From: Colin Jessey | Colin Jessey Associates [REDACTED]
Sent: 23 April 2013 11:10
To: James Smith
Cc: James Clark; [REDACTED]
Subject: RE: Fiddlers Green, Kingston (our ref: K/9/12)

Subject: Fiddlers Green, Kingston (our ref: K/9/12)

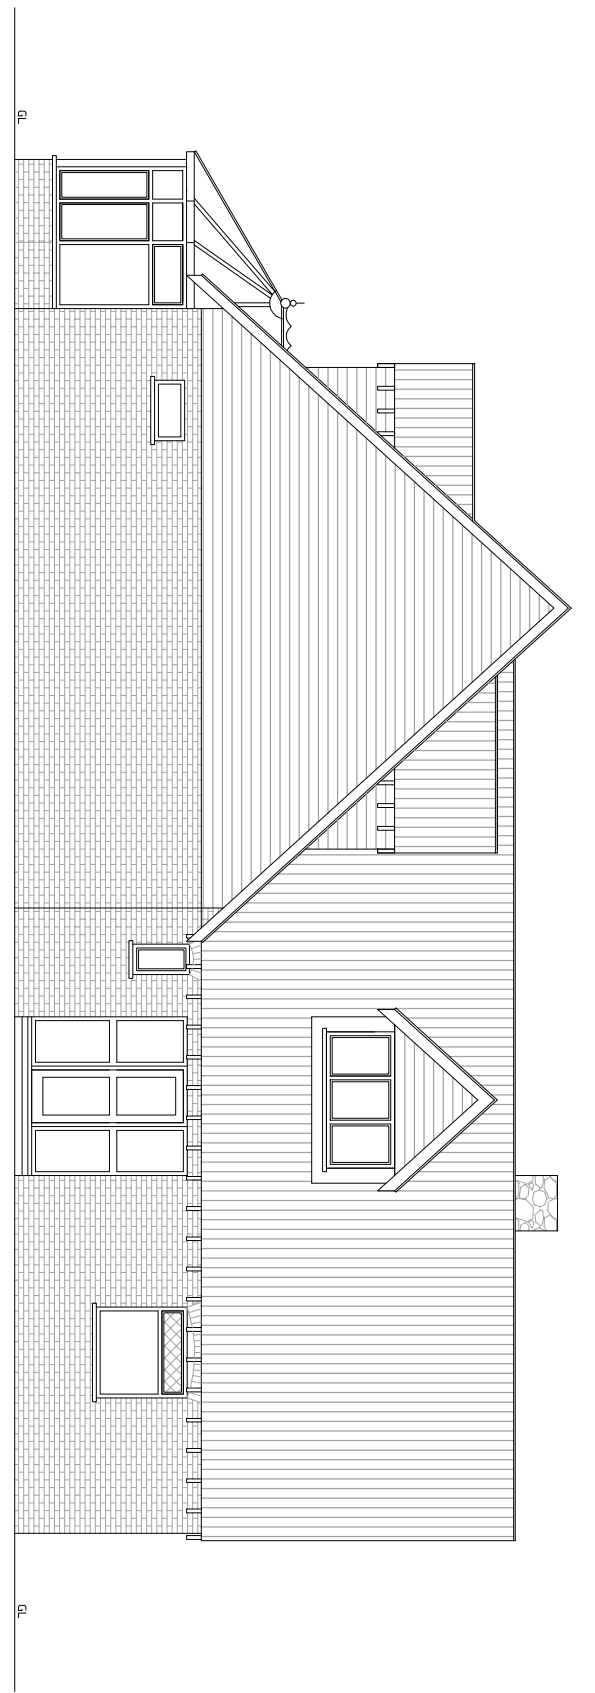
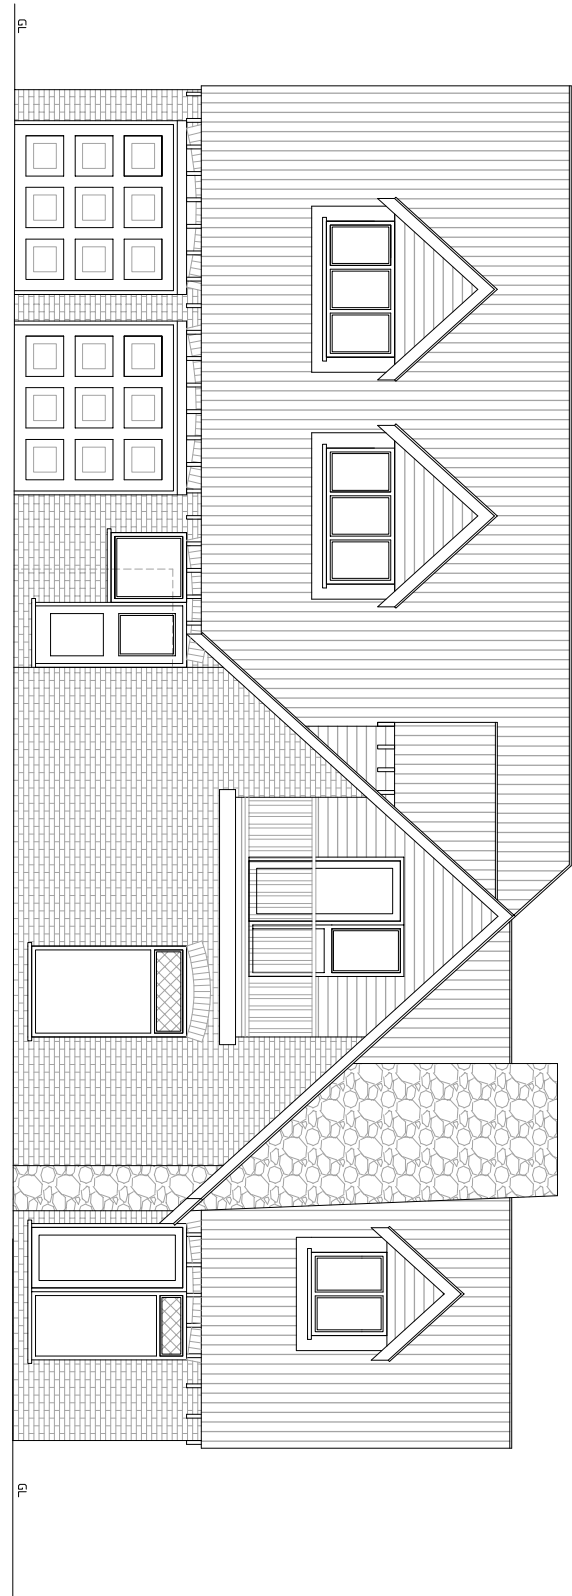
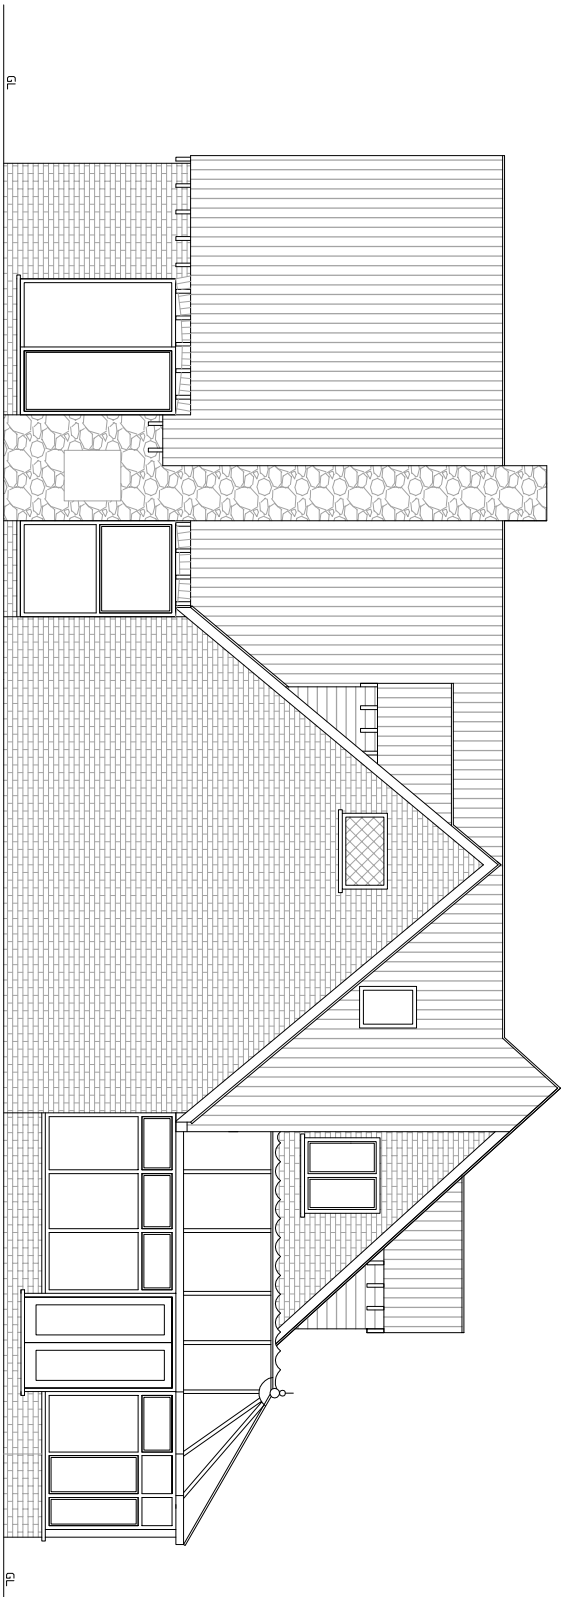
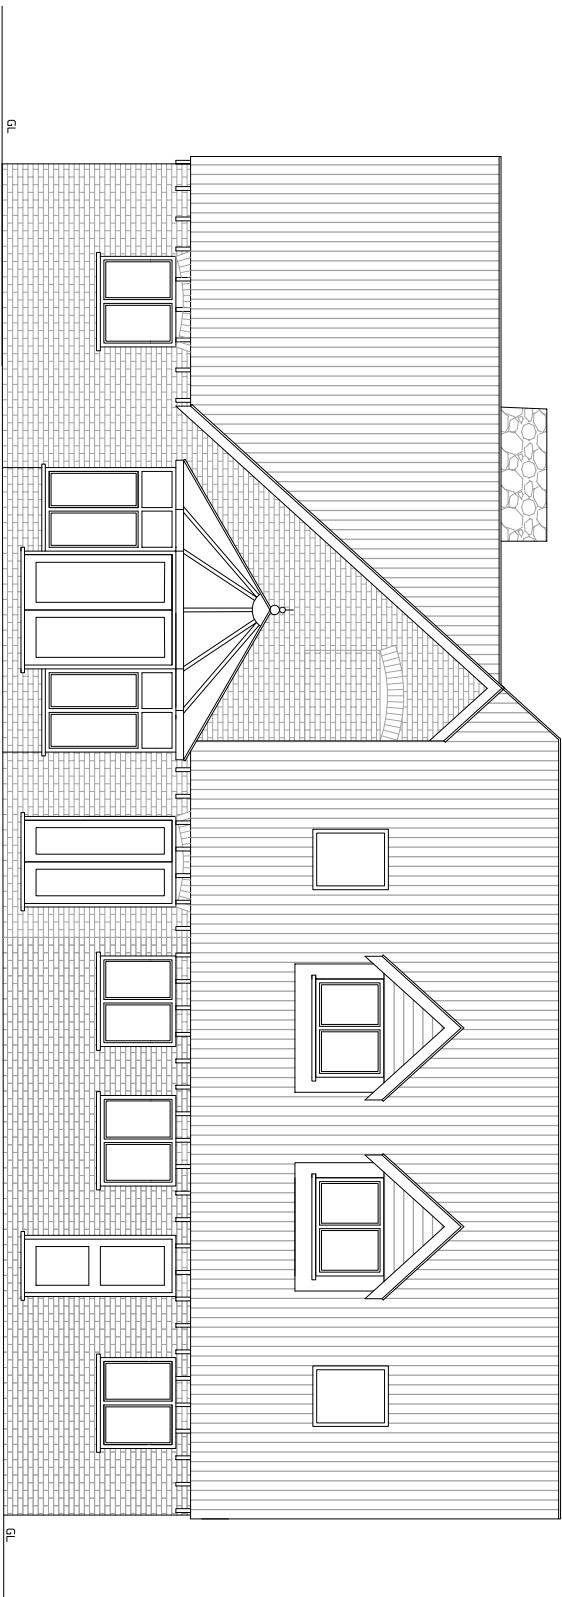
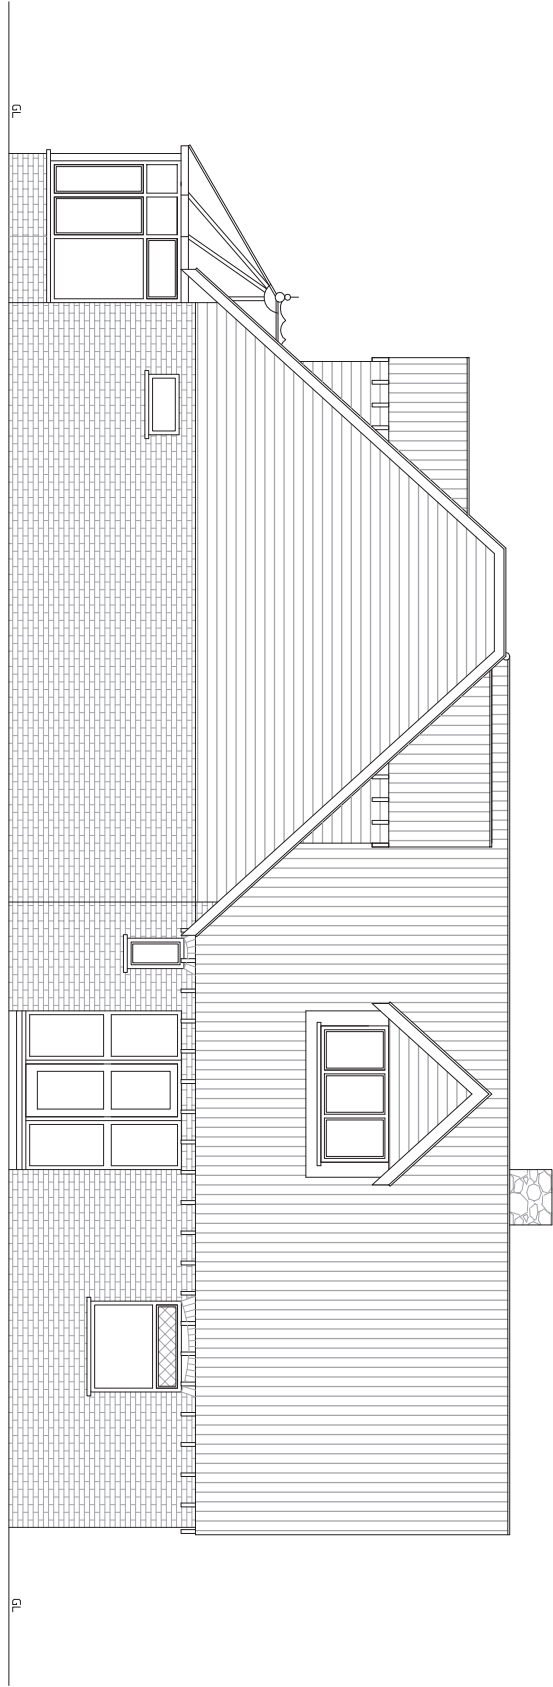
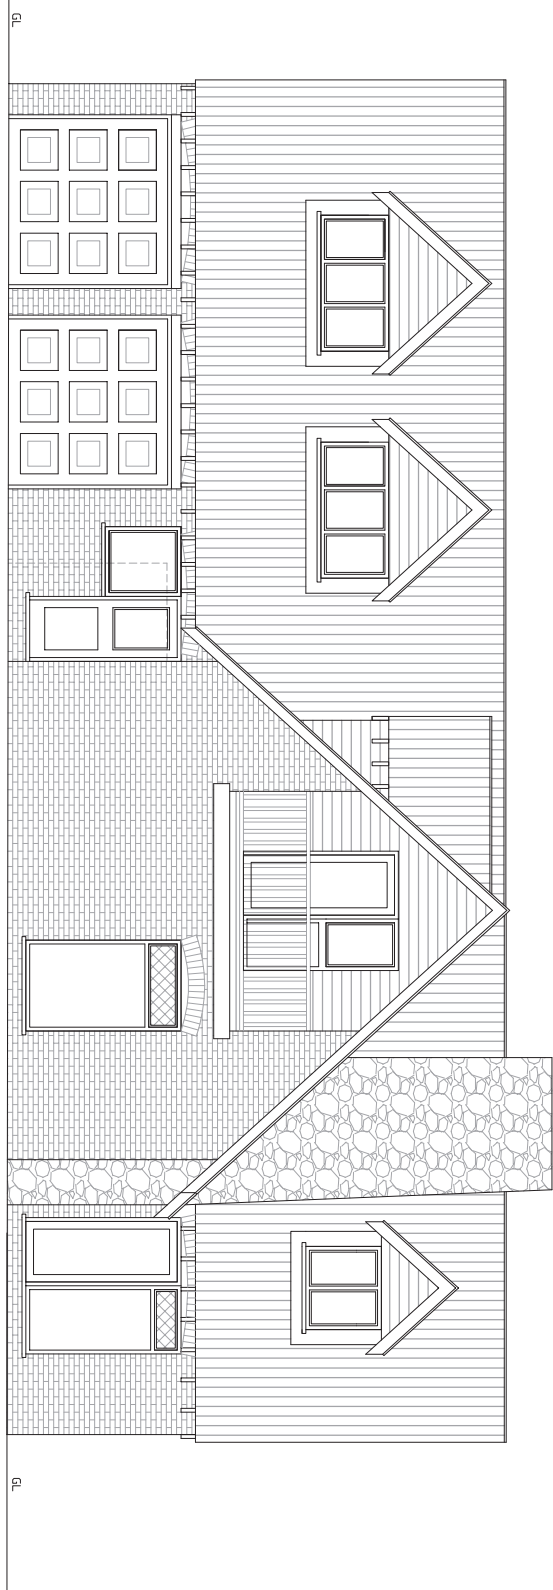
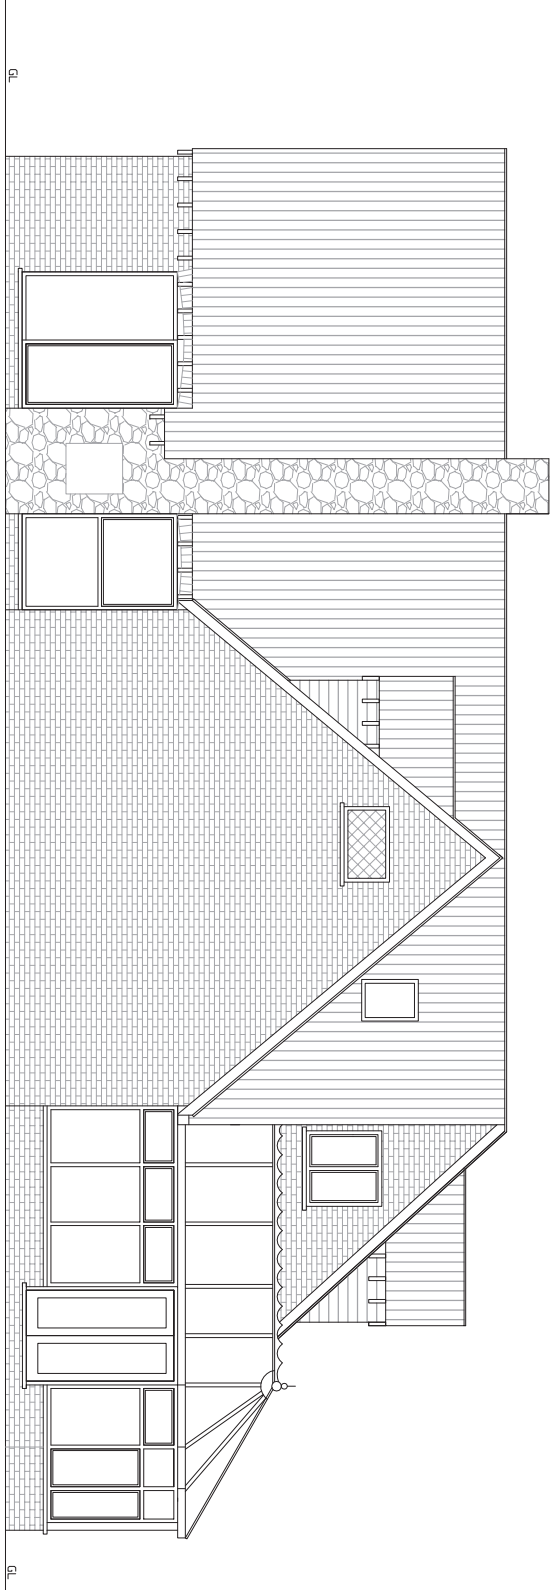
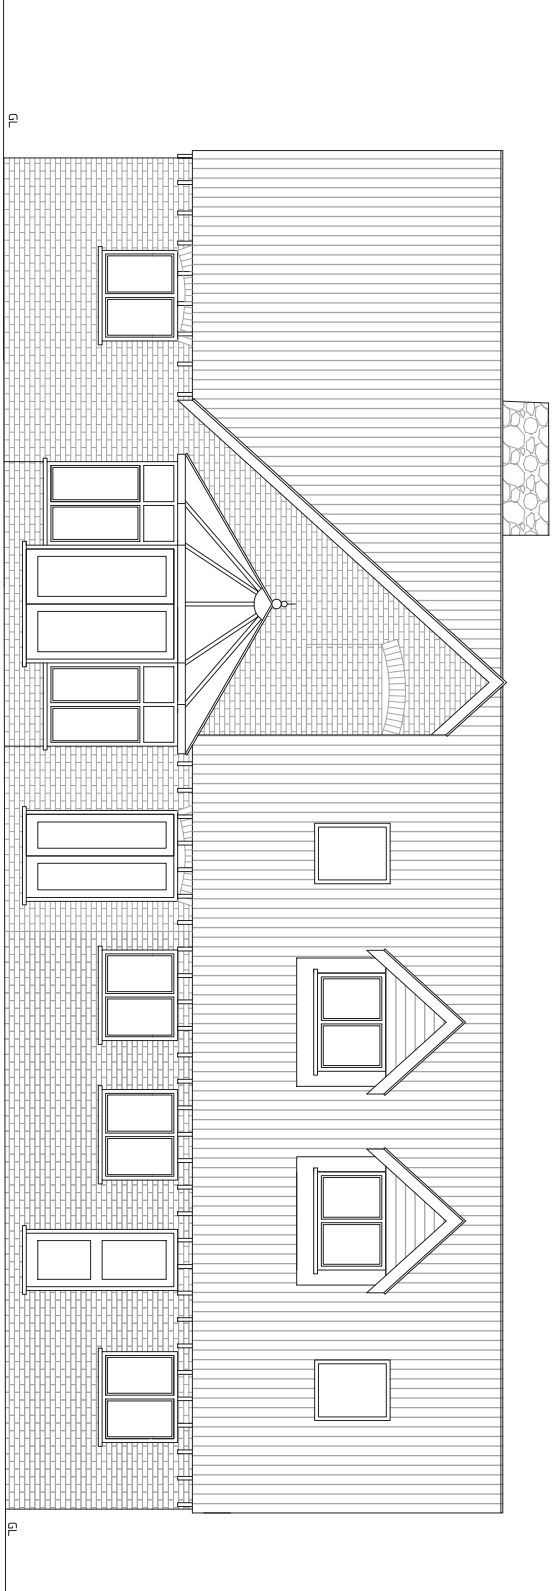
I have just been discussing the Fiddlers Green application with my team leader. He raised some concerns over the fact that the roof over the garage would be higher than that of the existing. I was presuming this has been done to ensure that the slope angle of the new roof matches that of the existing roof? As it stands we would be minded to refuse the application due to the height increase as the extension would not appear subservient towards the host dwelling and would have an unbalancing effect.

A possible workaround would be to maintain the matching slope angles but flatten the roof top where it matches the ridge height of the existing roof. Would this method be practical? If not, is there any other alternatives that we could consider. Addressing this concern would improve the prospects for the application.

The amendment allows for a reduction in the height of the extension, to align with the existing ridge.

This is to be achieved with a small flat crown roof, faced on the front leading edge with a ridge tile. Although it will not be seen, the flat crown roof is to be finished in a high performance mineral felt, colour brown to match the roof tiles. This proposal ensures that the pitch of the new roof shall match the existing roof.
